DRB CASE ACTION LOG (Preliminary/Final)

DRB Application No.: 11DRB-70311

Project # 1009039

Project Name: Netherwood Park Addn Tracts B-1A Through B-1F

**PLAT OF
TRACTS B-1F-A, B-1F-B & B-1F-C
NETHERWOOD PARK ADDITION
SECTION 11 T. 10 N., R. 3 E., N.M.P.M.
CITY OF ALBUQUERQUE
BERNALILLO COUNTY, NEW MEXICO
NOVEMBER 2011
SHEET 2 OF 2**

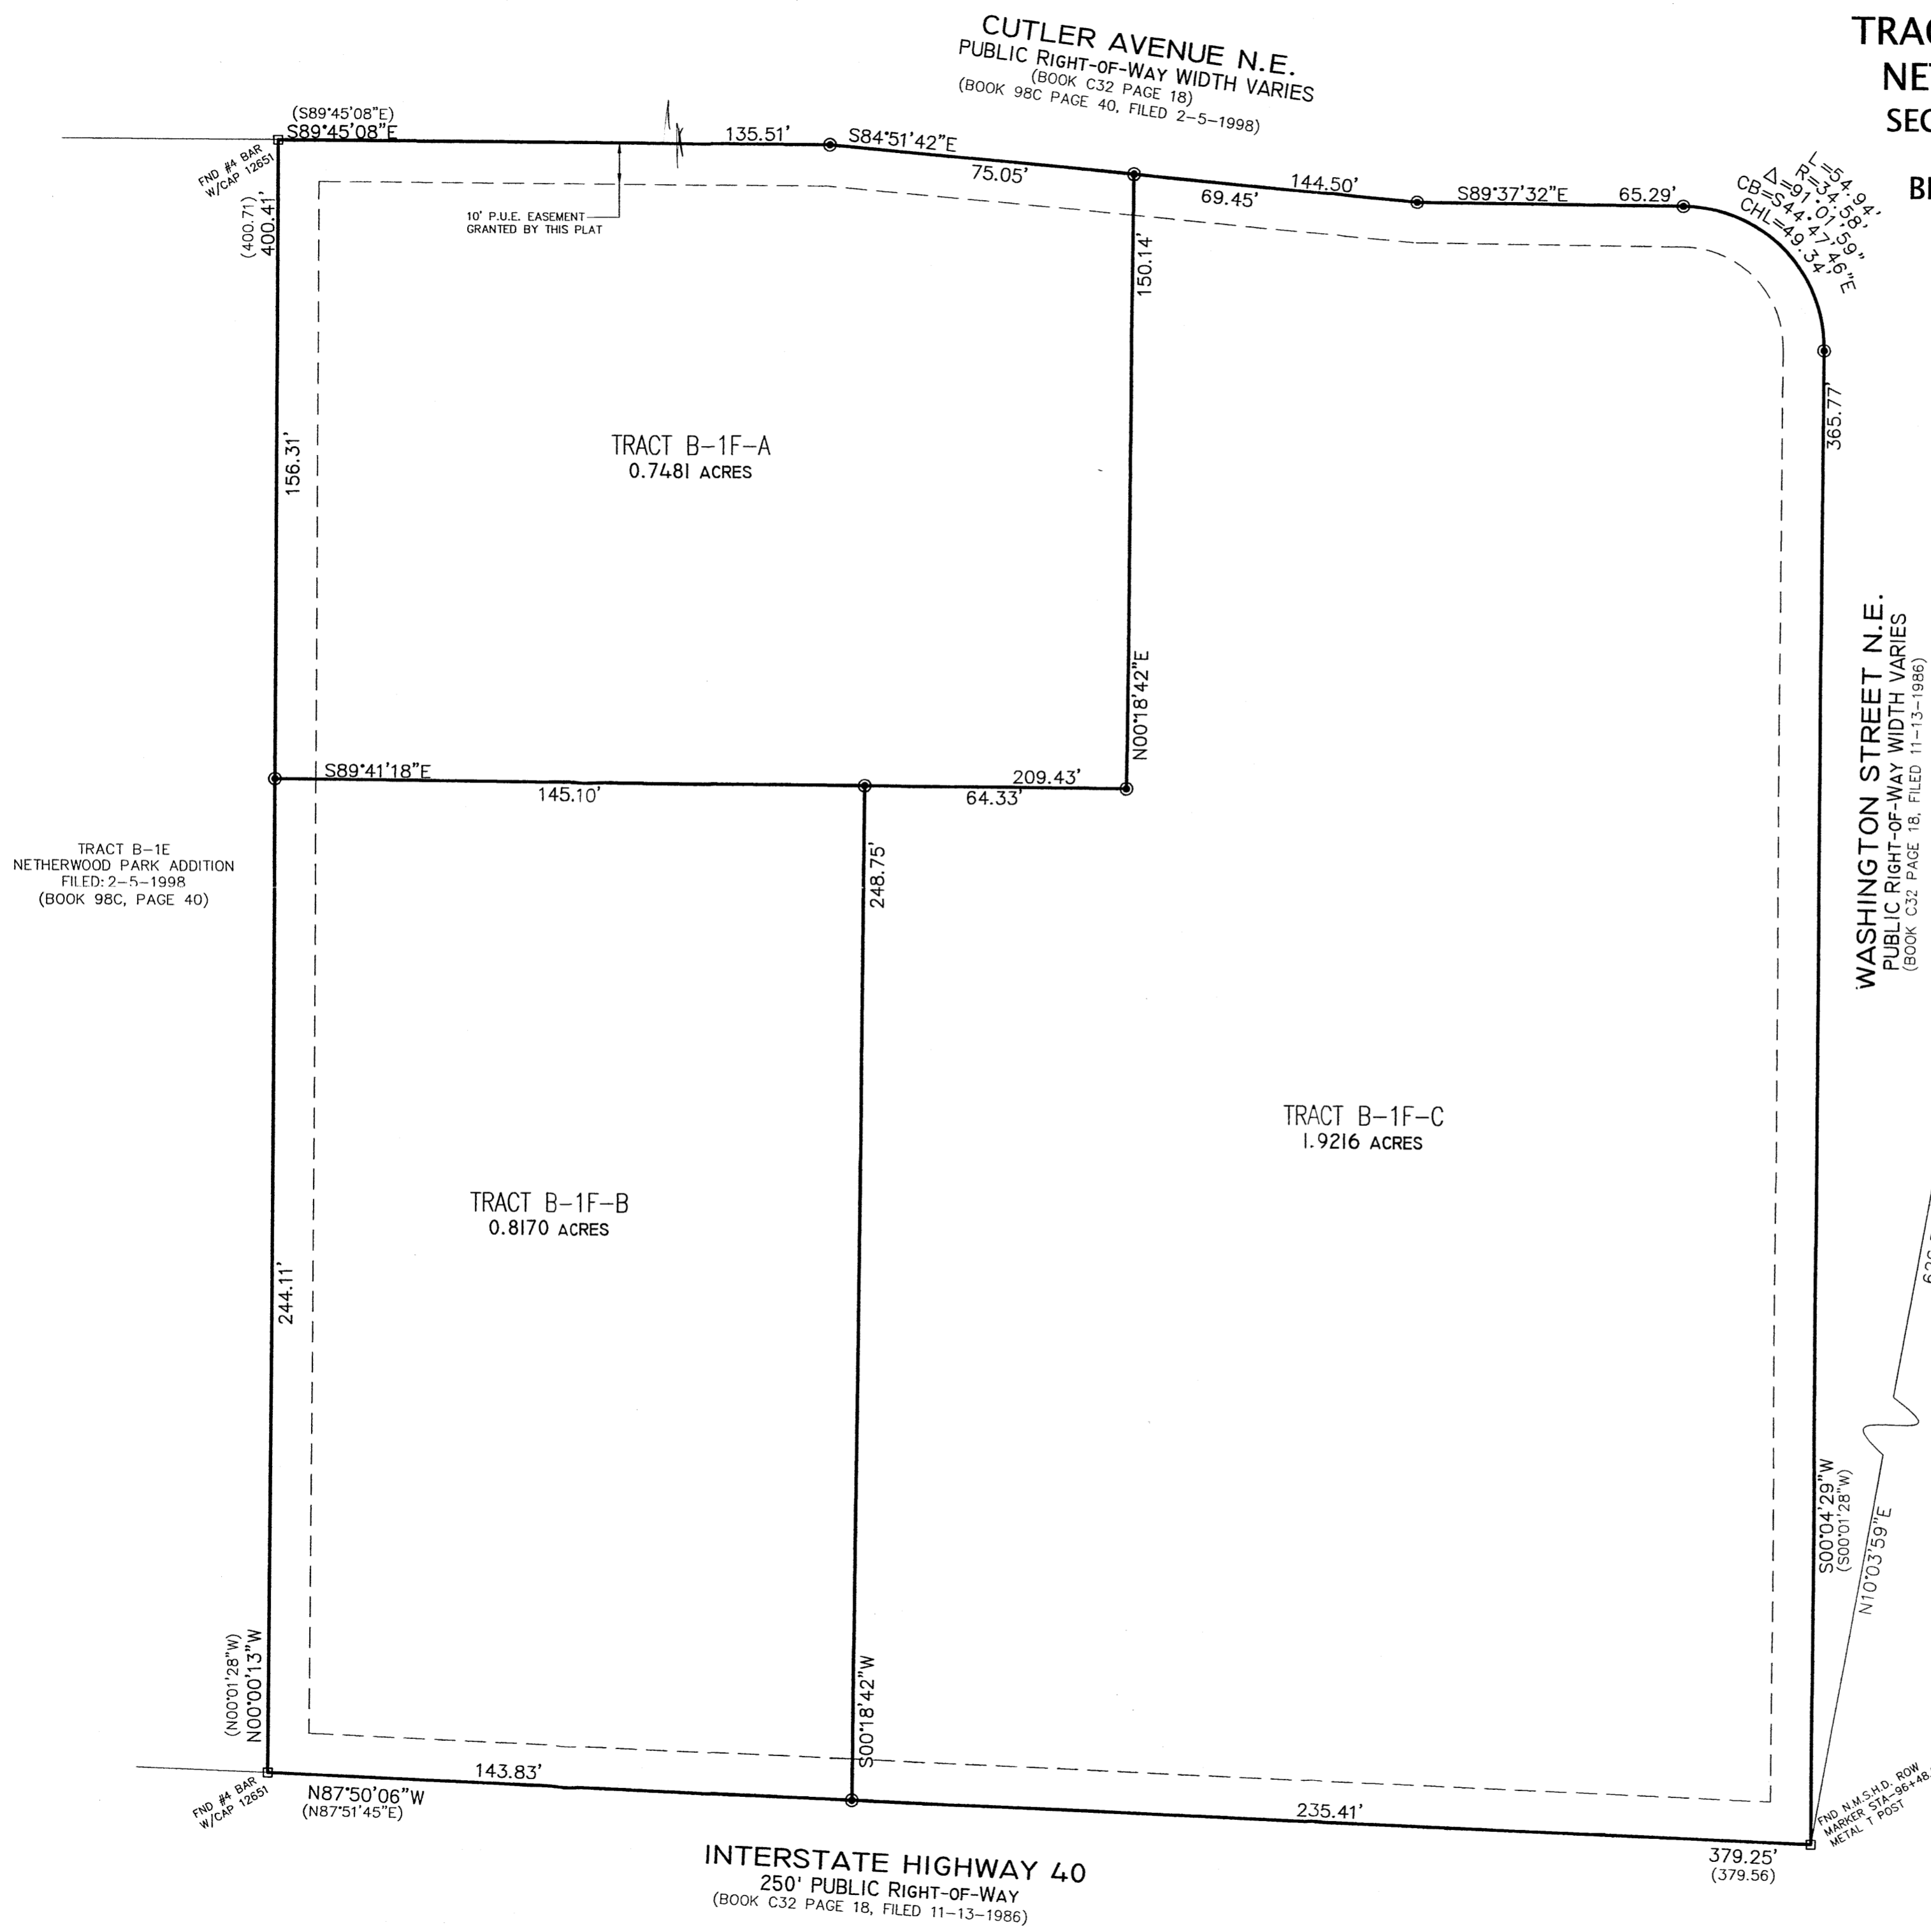
ABCWUA: Provide W & S Easement

PLANNING (Last to sign): dxp - show access limits
